Planning Application Ref: FP/228/20/T

Location: Outside 17/19 and Outside 23 Wyke Lane North, Felpham, PO22 8LE

Description of works: Fell 1no. ash tree. Reduce crown of 1no. cherry tree to height approx. 7.5m and spread approx. 7m

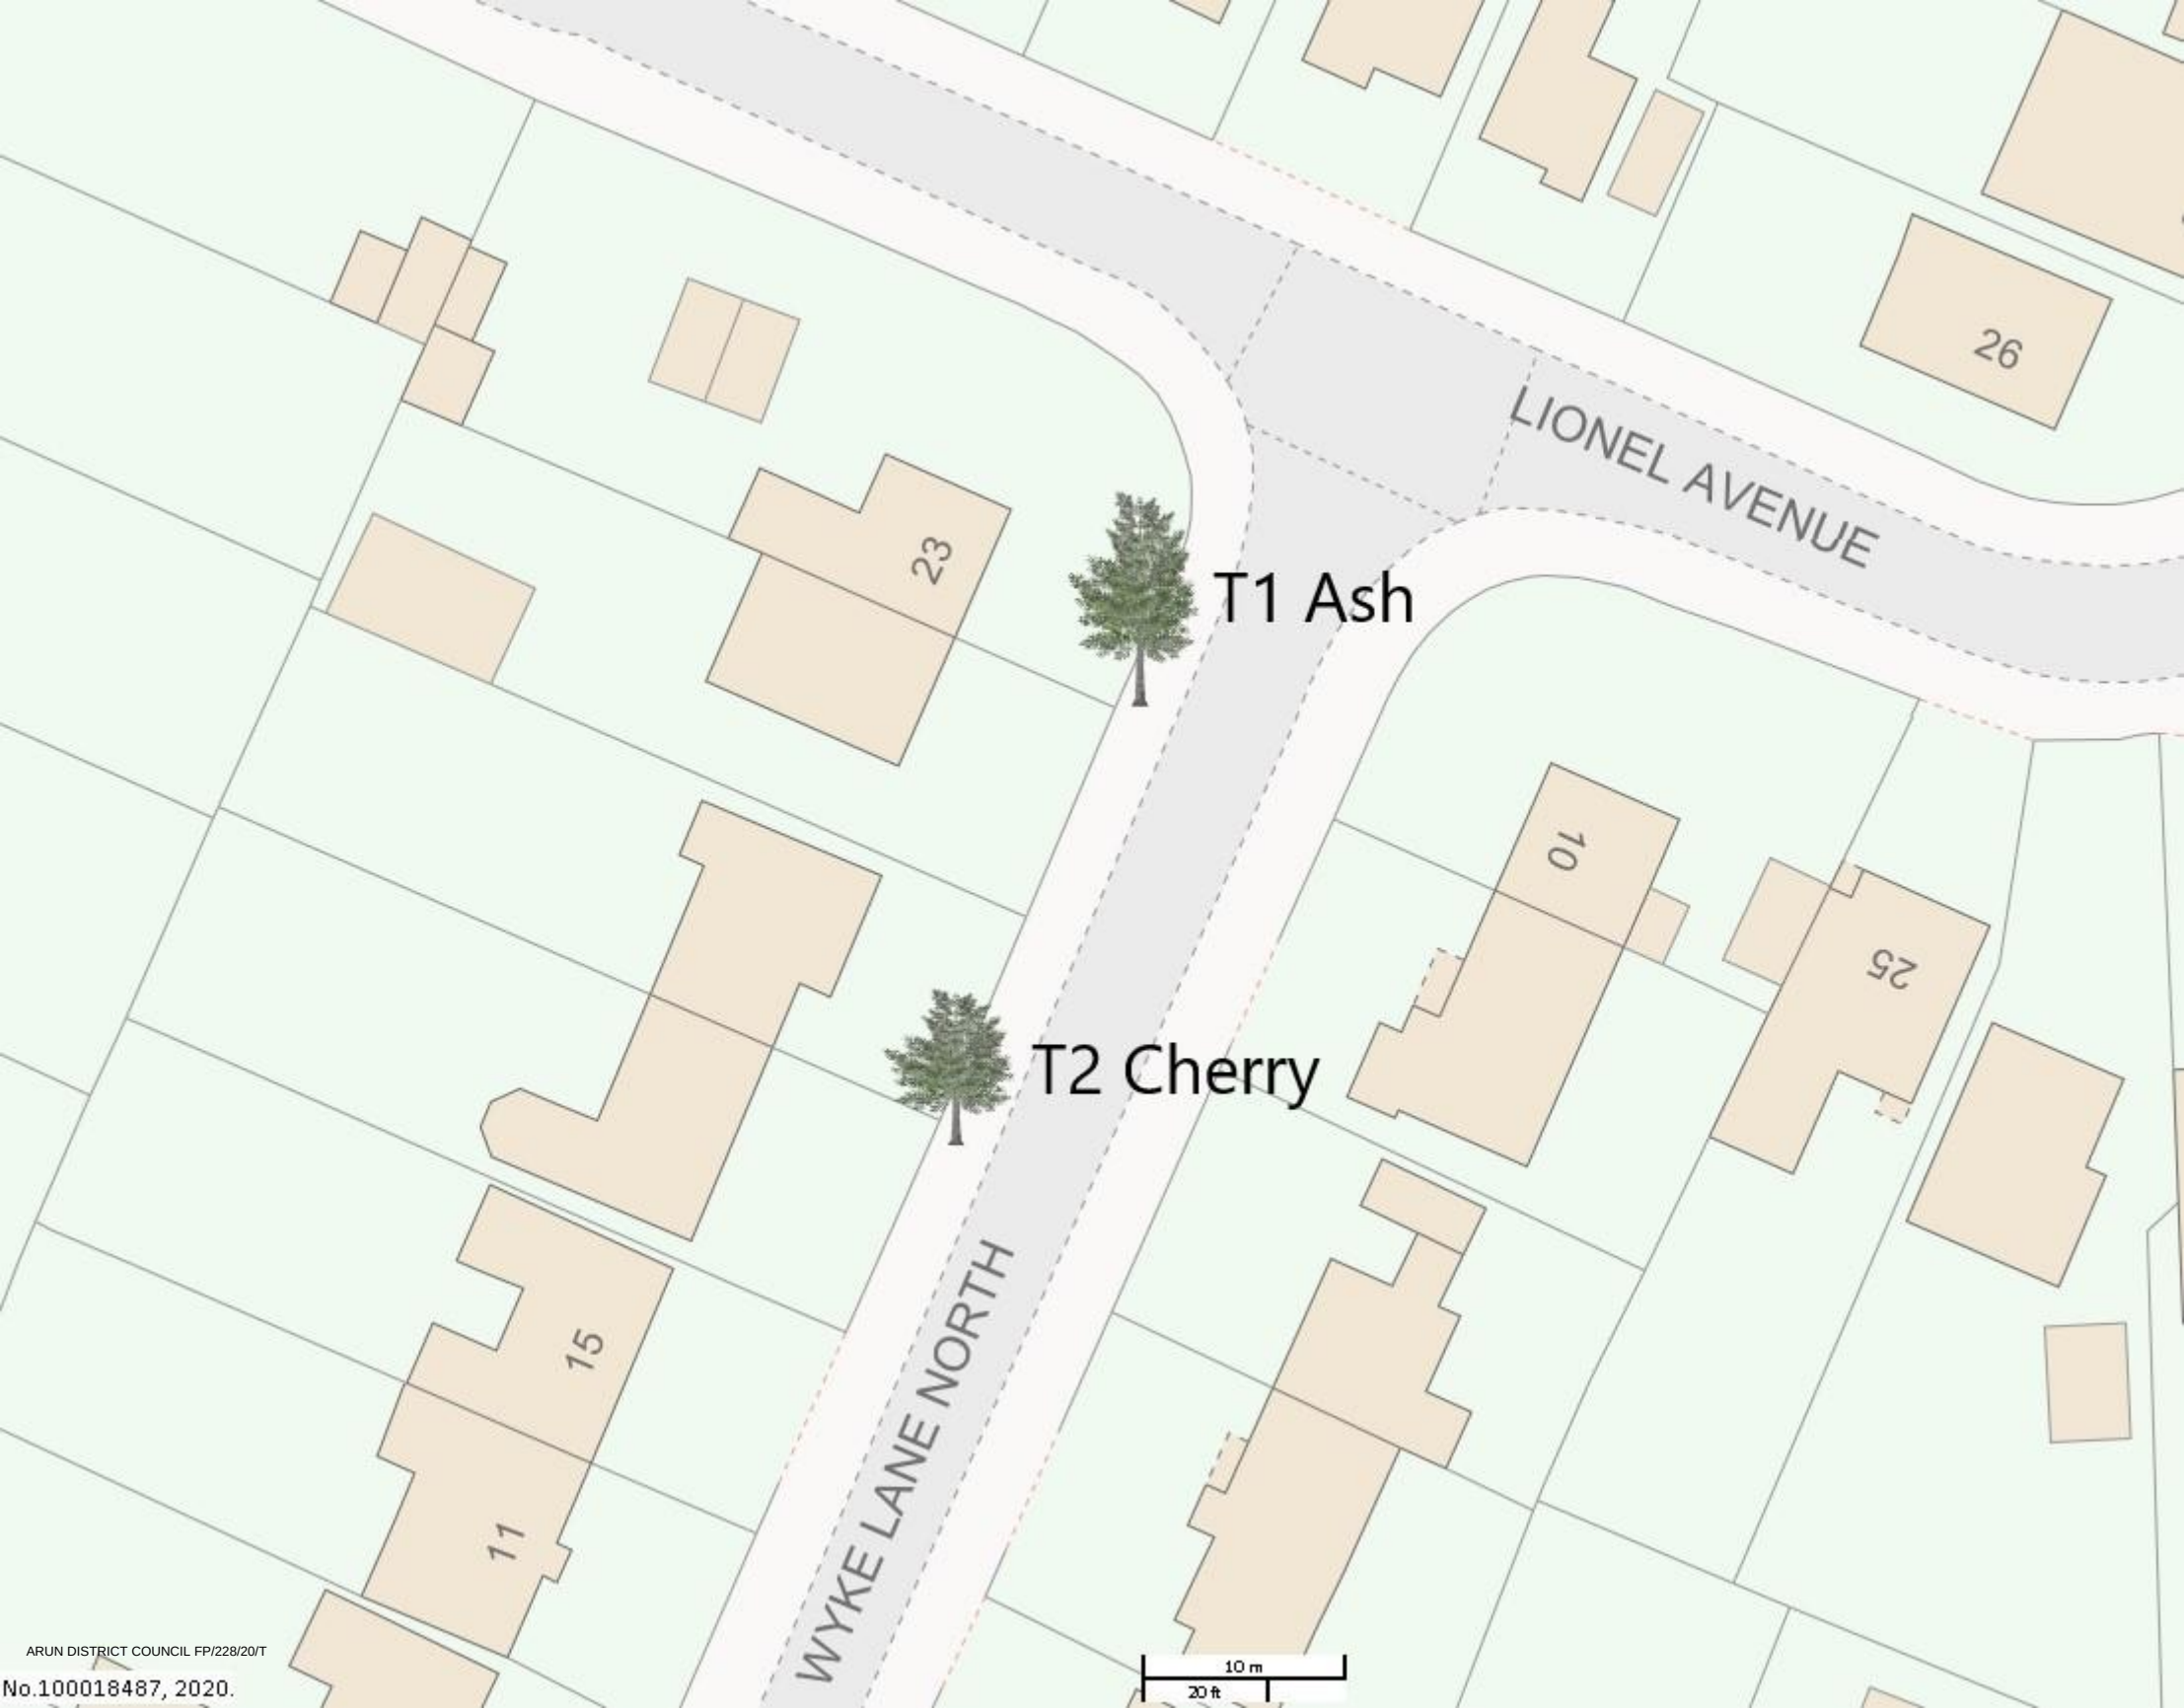
- Viewed from afar during dormancy, **T1** appears to be in a fine physiological state. It has good form and presents an attractive crown profile. A prominent and visually impressive tree.

- My own close inspection revealed weak shoot extension on those branches at low level and somewhat undersized twigs and buds. Several unidentifiable (frozen) fungal brackets had emerged from between buttress roots and at the stem base, suggesting an extensive and significant decay event. This may be in addition to the *Chalara* dieback episode reported; the evident upper crown tip dieback and relatively high deadwood content are typical of the latter stages of such an infection.

- **T2** cherry is an ornamental tree with character and an attractive, open crown. Outwardly it appears to be in a fine physiological state with only a little canker present on scaffold limbs. Recent impact from a high-sided vehicle has resulted in a large tear-out wound around the crown-break which will not occlude and is therefore likely to provide an entry point for harmful decay fungi.

- While no obvious significant structural defect exists, a sympathetic reduction of the crown as proposed will ensure it is proportionate with and clear from adjacent highway and garden, incurring no significant reduction in amenity.

- **T1** - The work proposed is necessary to remove a confirmed developing risk of catastrophic failure and so justified on arboricultural grounds.
- **T2** - While a temporary loss of aesthetic value is inevitable, satisfactory canopy renewal and recovery should occur if the work is undertaken to a high standard and at an appropriate time of year.

- Once the ash tree has been felled (and either grubbed or ground out) then a replacement tree is to be planted in the same place or nearby and to within 5metres.

- Part a) Where whole branches are to be removed and final cuts made close to the trunk or branch union they are to be made as shown in Figure 2 of BS3998:2010
- Part b) Where branches are to be shortened back the final cuts are to be made at the correct angle shown in BS3998:2010 and adjacent to a live bud or lateral.
